Subject: 65-71 Upper Bognor Road Bognor Regis PO21 1HR - BR/252/21/PL

Planning Application Reference: BR/252/21/PL

Address: 65-71 Upper Bognor Road Bognor Regis PO21 1HR

Drawing no.
5557-100-D6

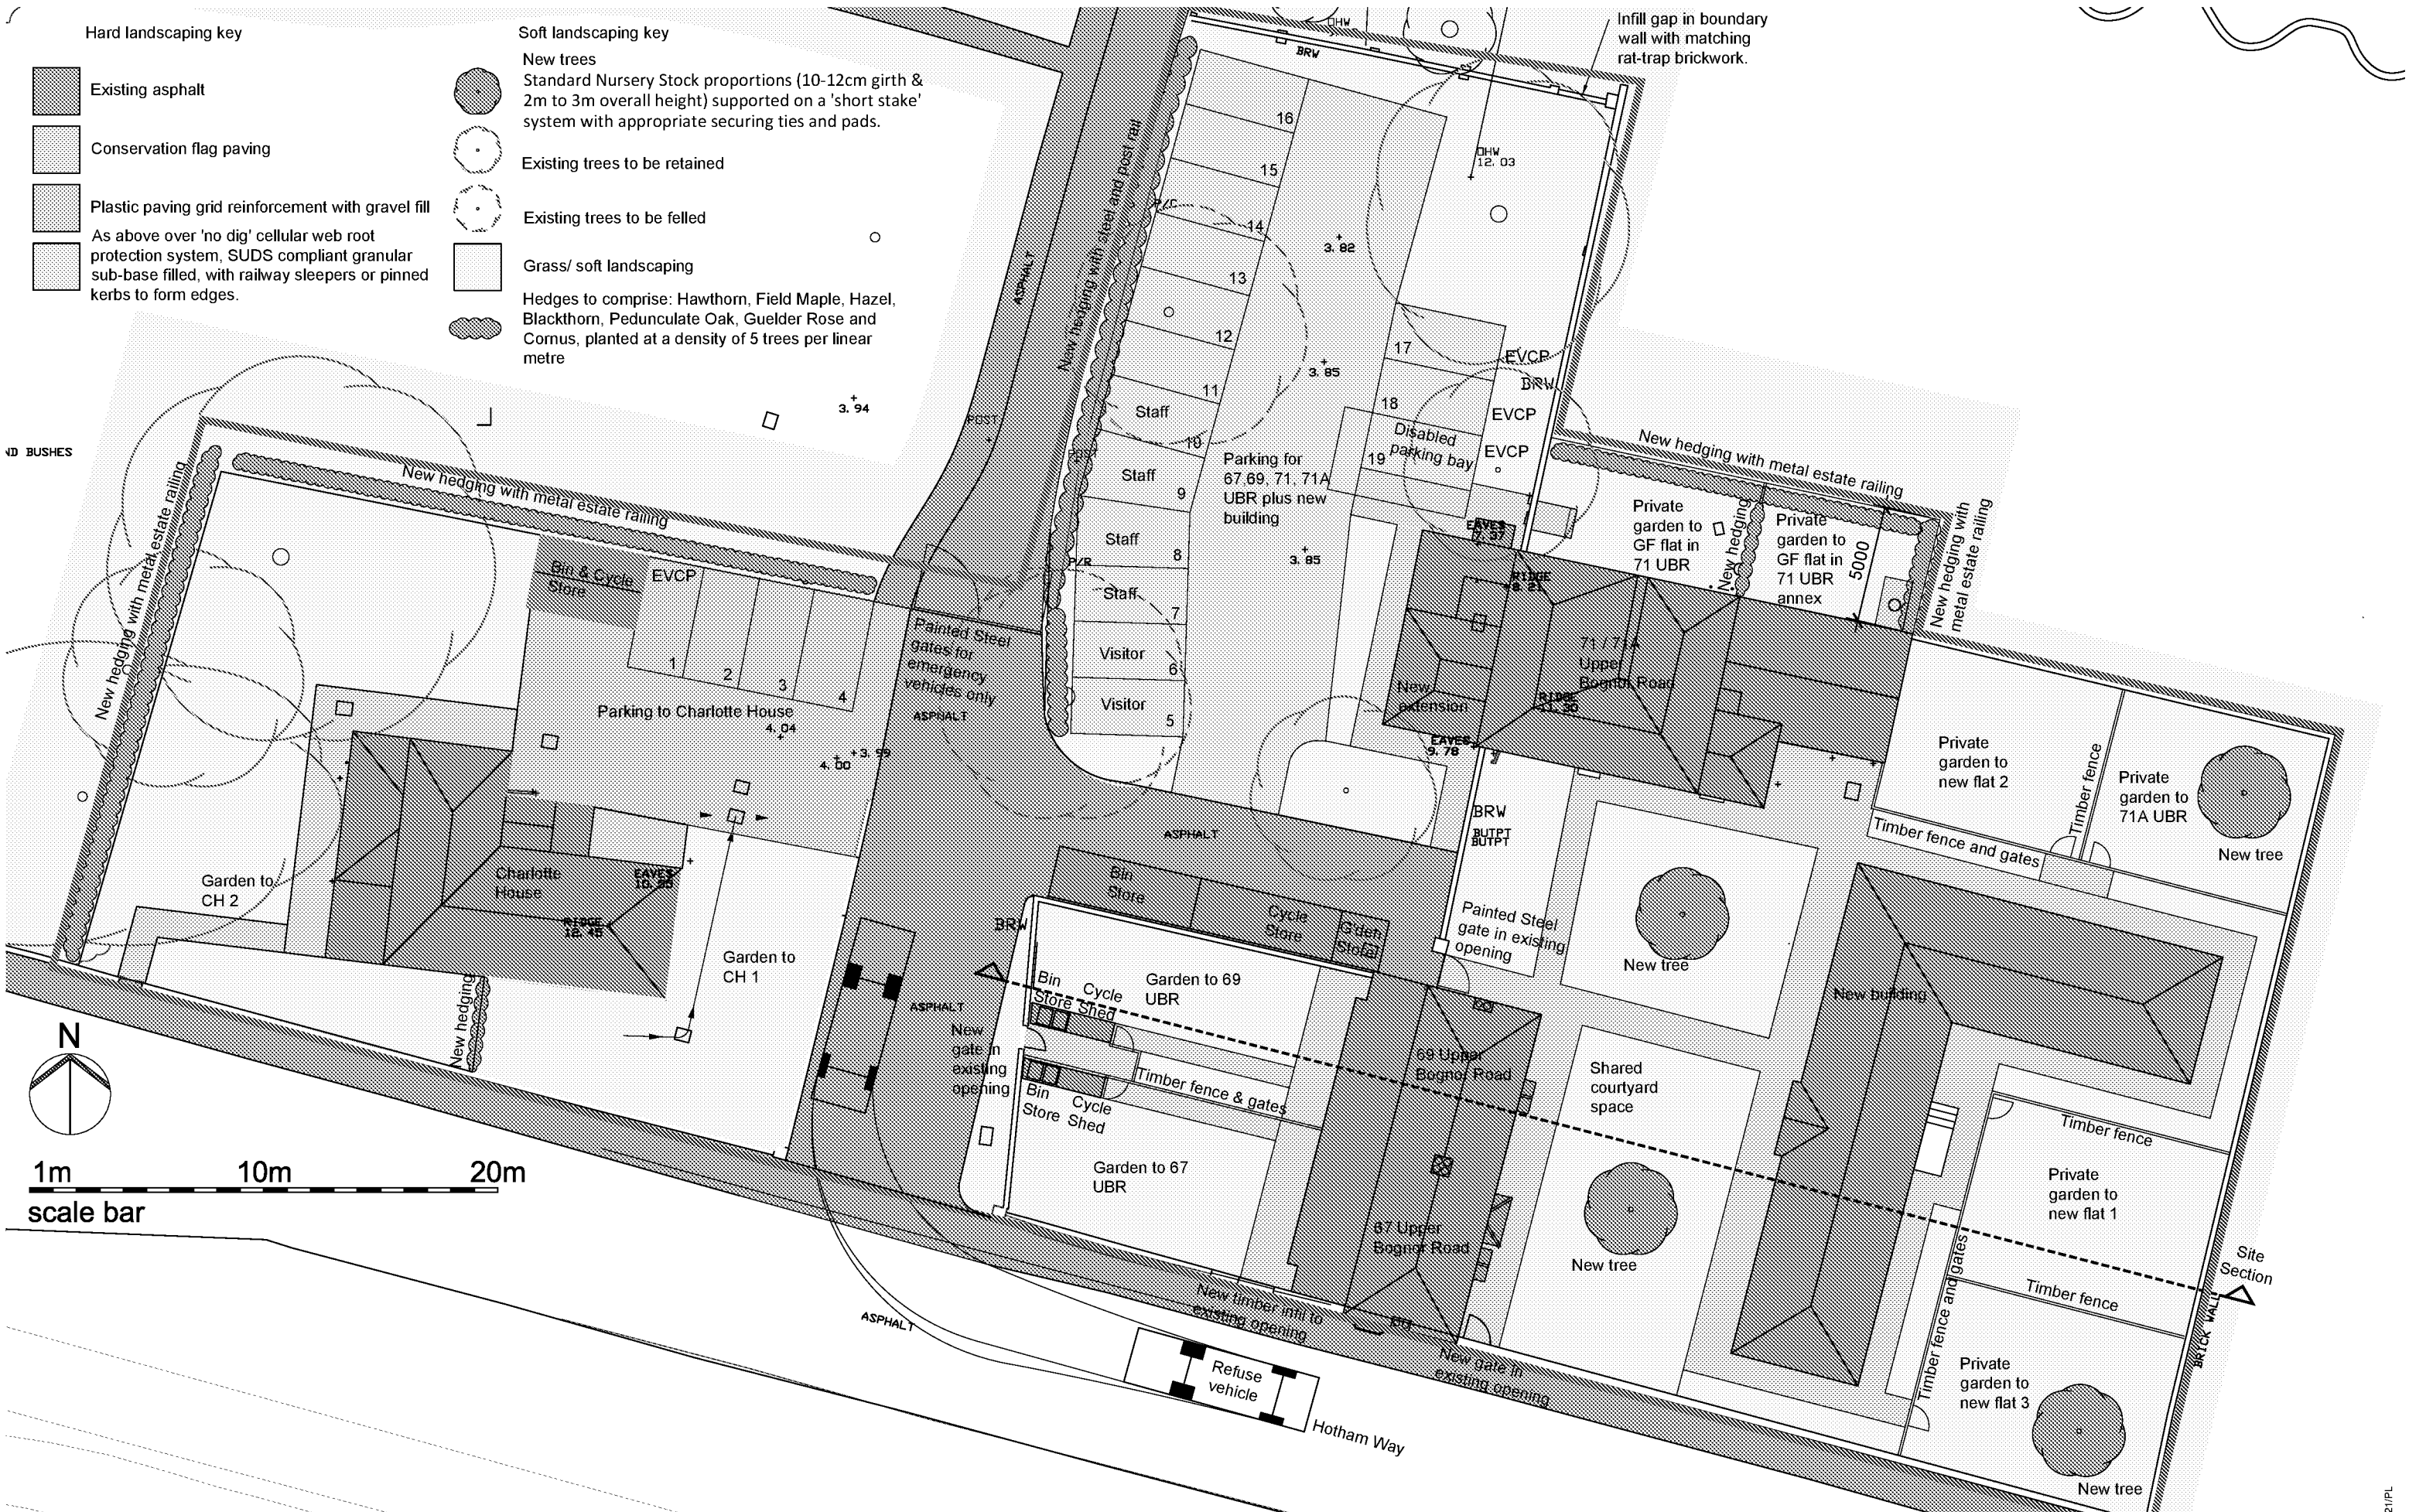
****** I note from 'proposed site plan 5557-012-D' that 4 EVCPs have been included. In accordance with recent government guidance, any new residential dwellings (or existing dwellings undergoing major

refurbishment) with dedicated parking must have 1 EVCP per dwelling. For new non-residential buildings (or existing buildings undergoing major refurbishment), every 1 in 5 parking spaces must include a EVCP.

Prior to occupation of any of the dwellings or first use of the commercial units, a scheme for the provision of facilities to enable the charging of electric vehicles to serve the approved development shall be submitted to the local planning authority for approval and thereafter implemented in accordance with the approved details and the charge points shall thereafter be retained and maintained in good working condition.
